WEST SUSSEX COUNTY COUNCIL CONSULTATION

TO:	Arun District Council FAO: Amber Willard
FROM:	WSCC - Highways Authority
DATE:	2 February 2022
LOCATION:	Kenwood, Barnham Road, Eastergate, PO20 3RS
SUBJECT:	BN/4/22/HH Erection of two storey side extension, front porch, installation of front boundary wall and gate and widen existing crossover.
DATE OF SITE VISIT:	N/A
RECOMMENDATION:	Advice
S106 CONTRIBUTION TOTAL:	N/A

Drawing P03 December 2021 Scale 1:100 / 1:500 @ A3
Planning Drawing - Site Plan, Road Elevation & Block Plan

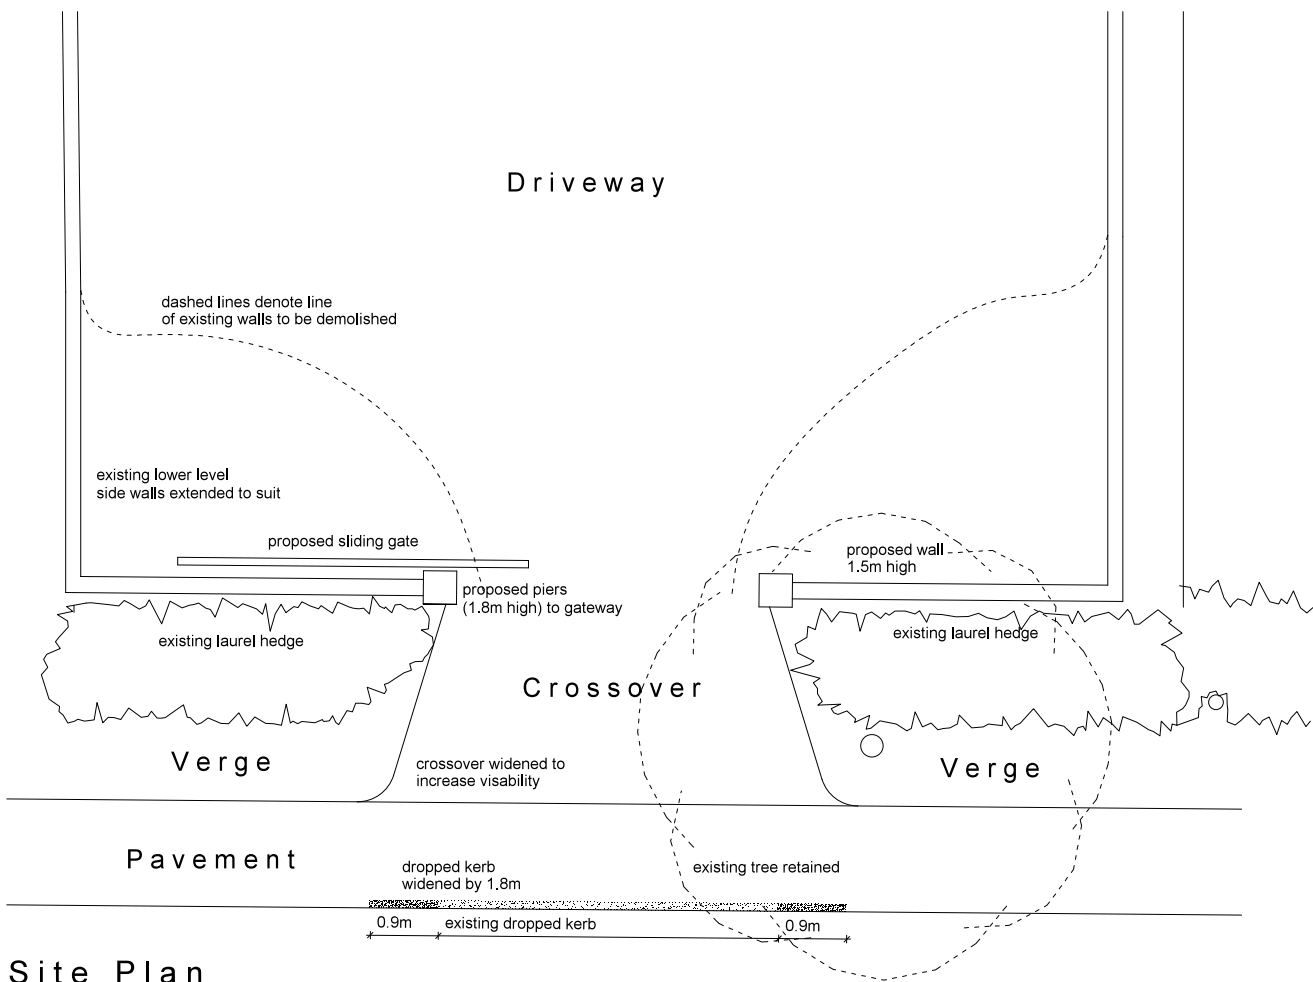
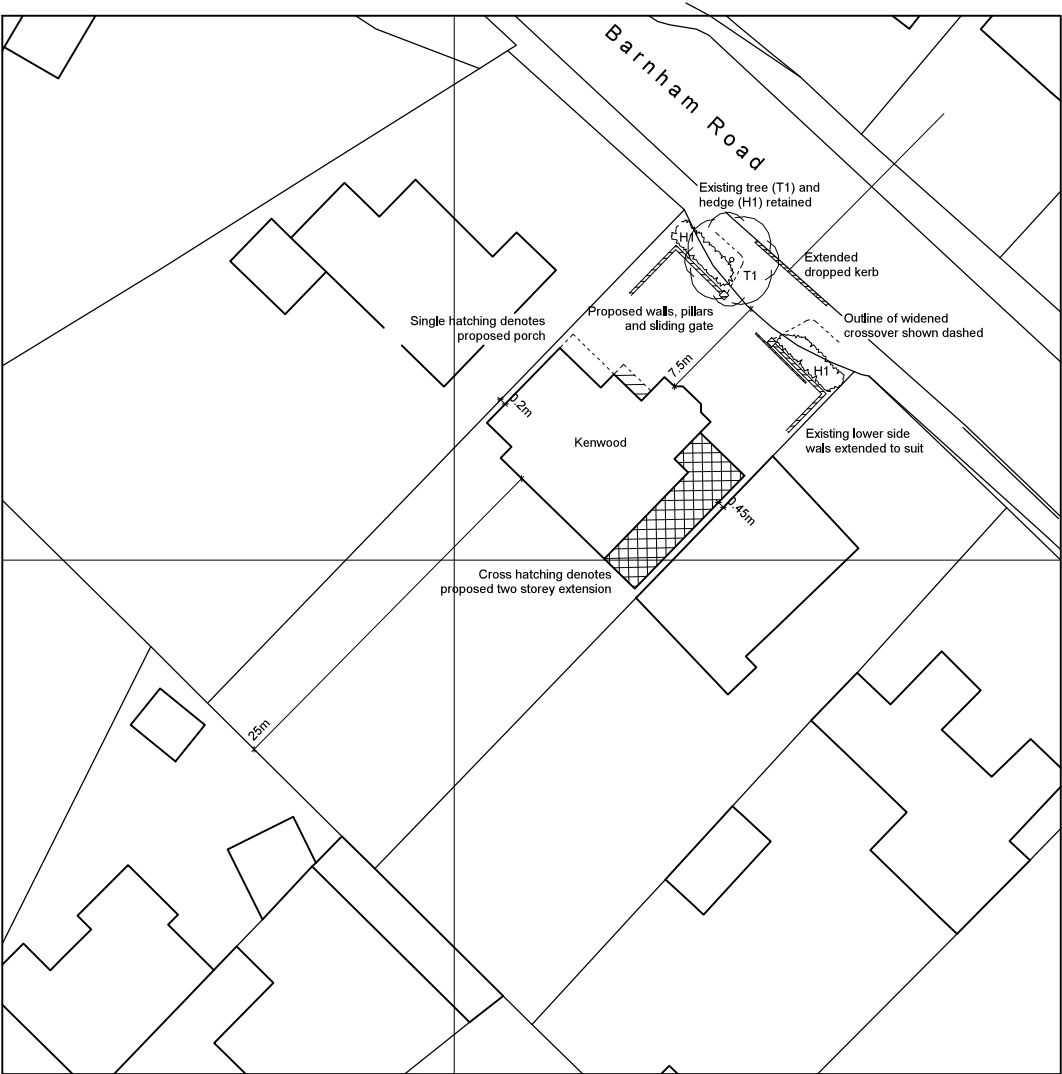
The applicant also proposes to widen an existing vehicle crossover (VCO) to approximately 6.3m, with the installation of a sliding entrance gate. The proposed VCO works will be subject to a licence obtained through the Local Area Office and constructed to a specification agreed with the Local Area Engineer.

Drawing P01 December 2021 Scale 1:100 @ A3
Planning Drawing - Floor Plans & Elevations

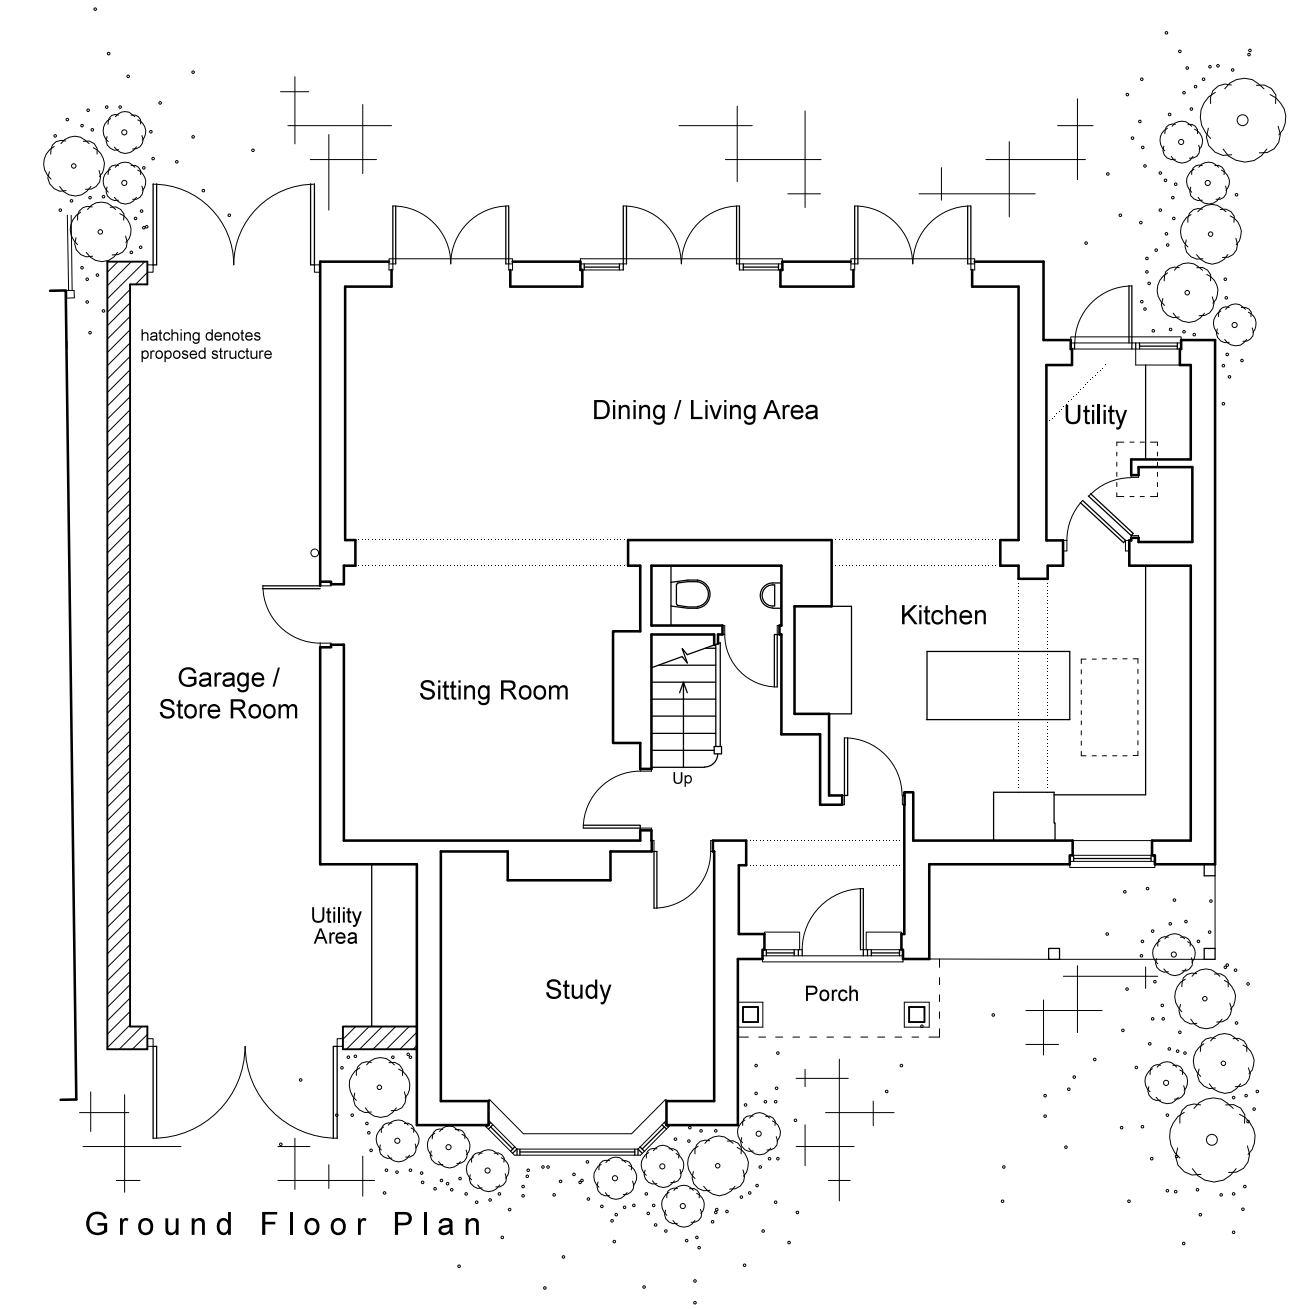
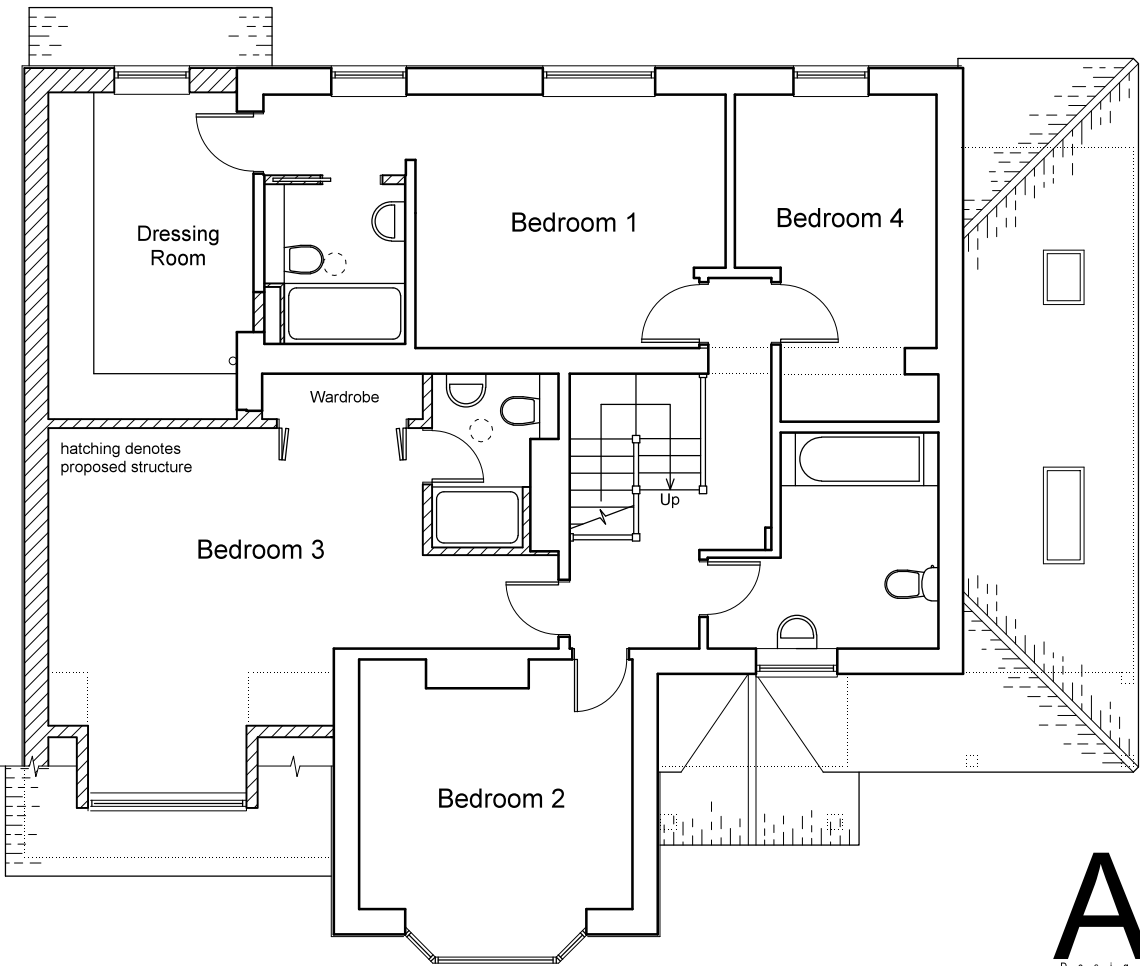
The LHA notes that the proposed garage will be approximately 2.5m wide at its narrowest point. This does not meet the minimum internal specifications of garages of 3m x 6m as set out in Manual for Streets (MfS). Therefore, the LHA advises the applicant to widen the garage to at least 3m in width, to ensure modern cars can be accommodated within. Notwithstanding this, the site benefits from a large driveway which can accommodate suitable parking provision for a dwelling of this size.
